Development Facilitation Team (DFT) – Review Comments

Project No: PR-2023-008999 Date: 03/13/2024 Agenda Item: #3 Zone Atlas Page: S-14, S-15, S-16, S-17

Request: Bulk Land Plat Innovation Park III Tracts A-N

Application For: SD-2024-00013-BULK LAND PLAT

BULK LAND PLAT
INNOVATION PARK III
TRACTS A-N
 (BEING A REPLAT OF TRACT 18 ARTISTE)
 CITY OF ALBUQUERQUE
 BERNALILLO COUNTY, NEW MEXICO
 JANUARY, 2024

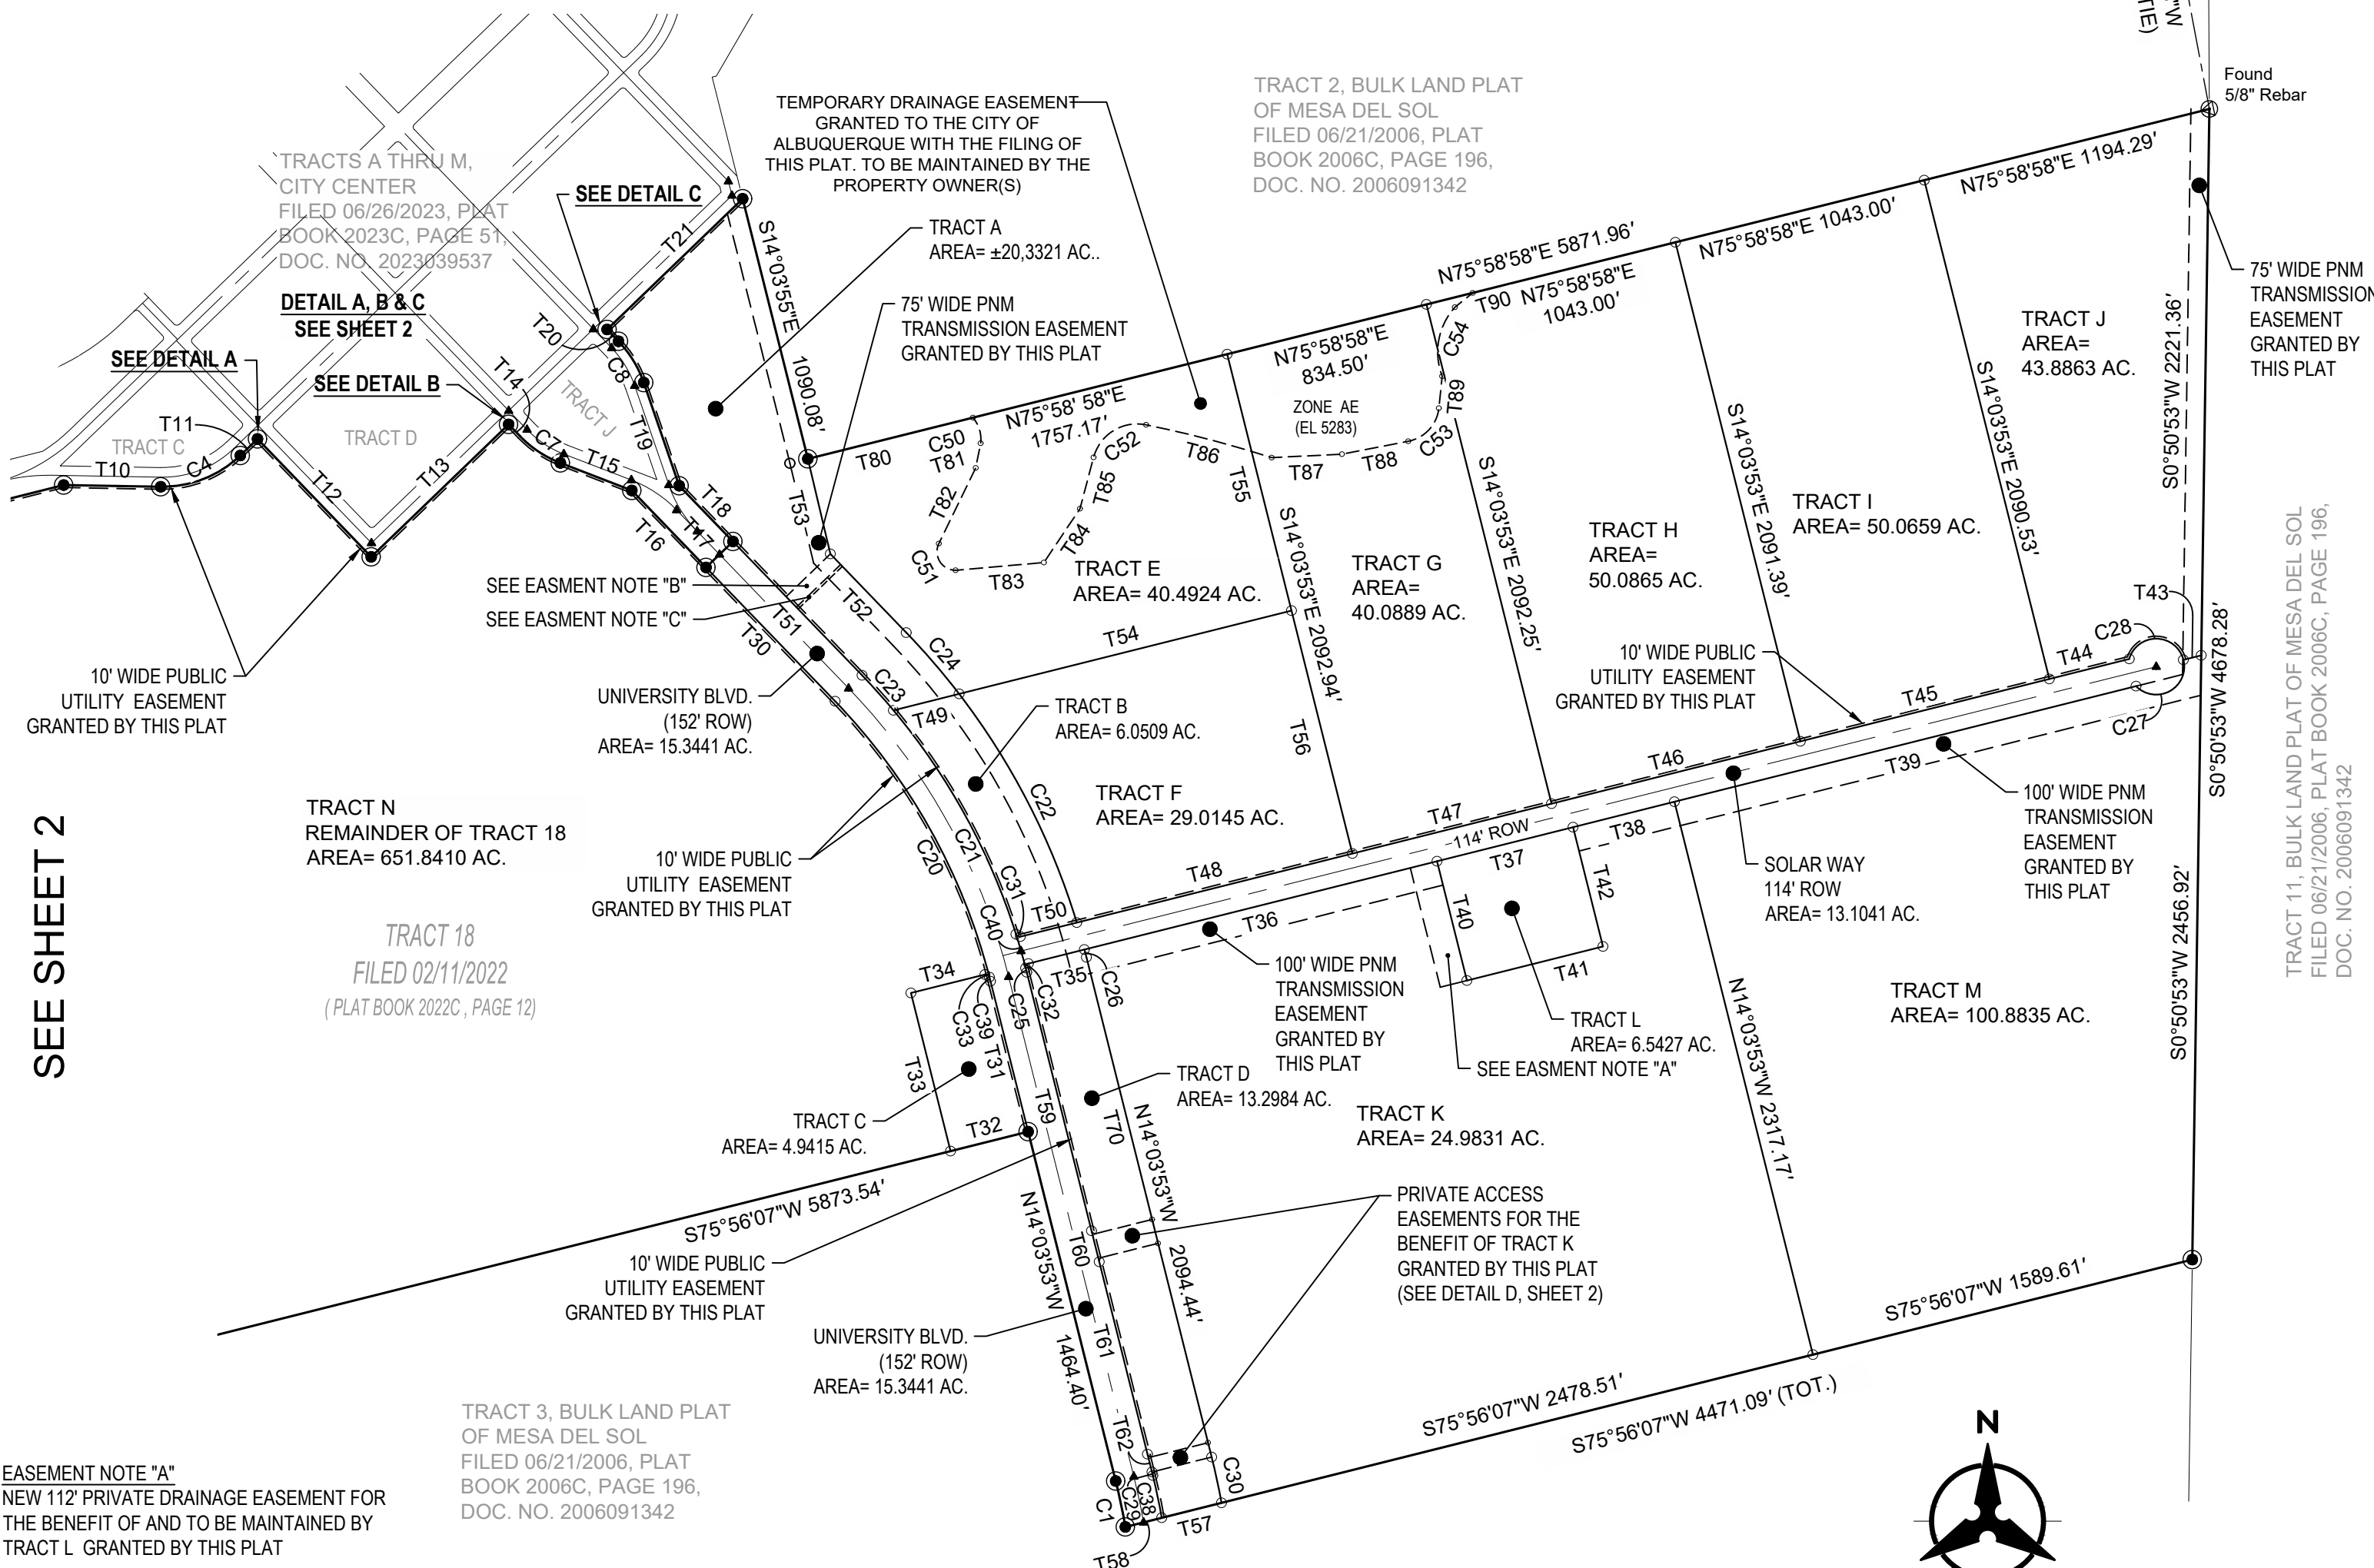
- The acreage for Tract K appears to be incorrect; Tract K is depicted as being 24.9831-acres in size on the Plat, while the site area of the Site Plan Administrative DFT currently under review on the site is approximately 125-acres. Please confirm if the acreage for Tract K is incorrect, and correct the acreage for Tract K on the Plat if needed.

**BULK LAND PLAT**  
**INNOVATION PARK III**  
**TRACTS A-N**  
(BEING A REPLAT OF TRACT 18 ARTISTE)  
**CITY OF ALBUQUERQUE**  
**BERNALILLO COUNTY, NEW MEXICO**  
**JANUARY, 2024**

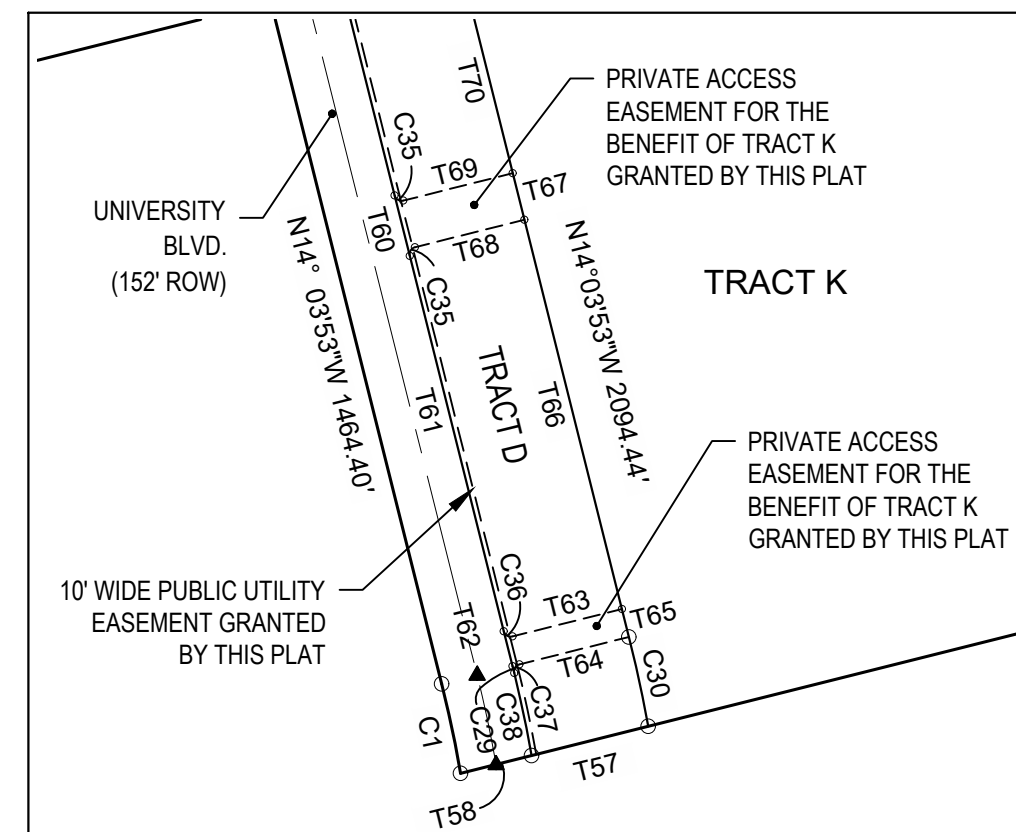
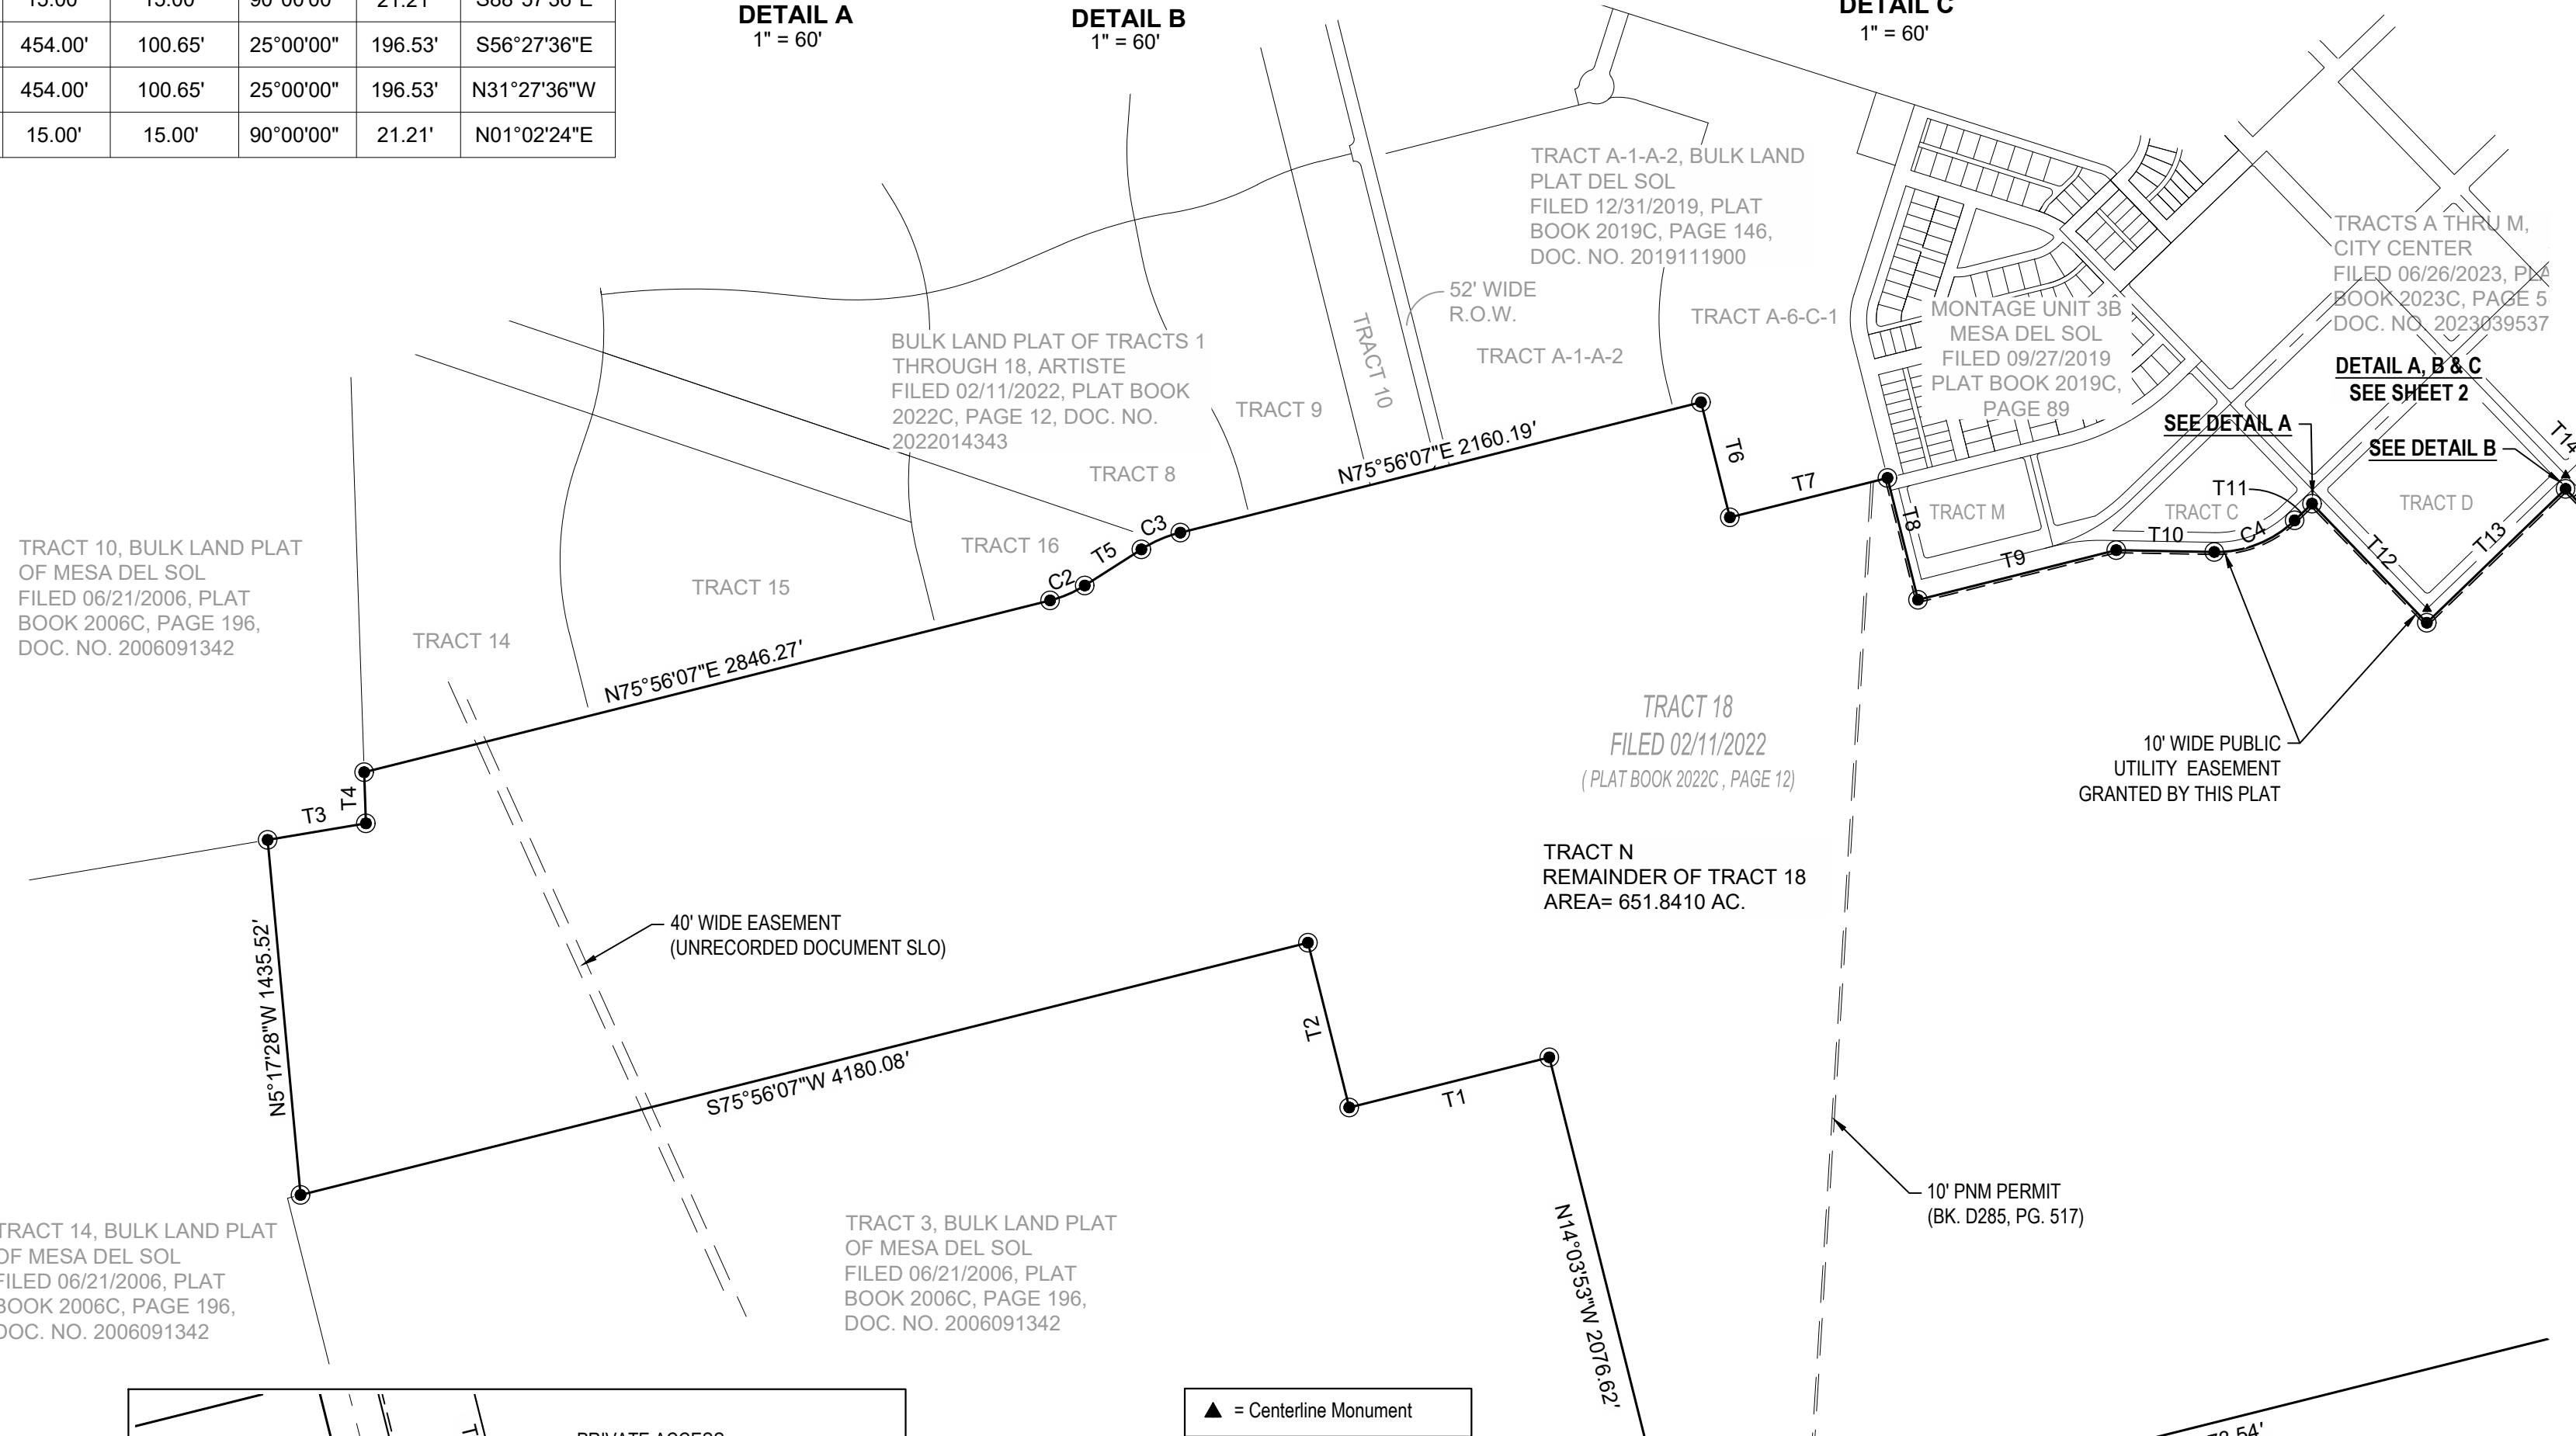
1. Previous comments still apply
 - a. How will Tract 11, get service?
 - i. Please provide a public water and public sanitary sewer easement across Tract M or J to make the connection.
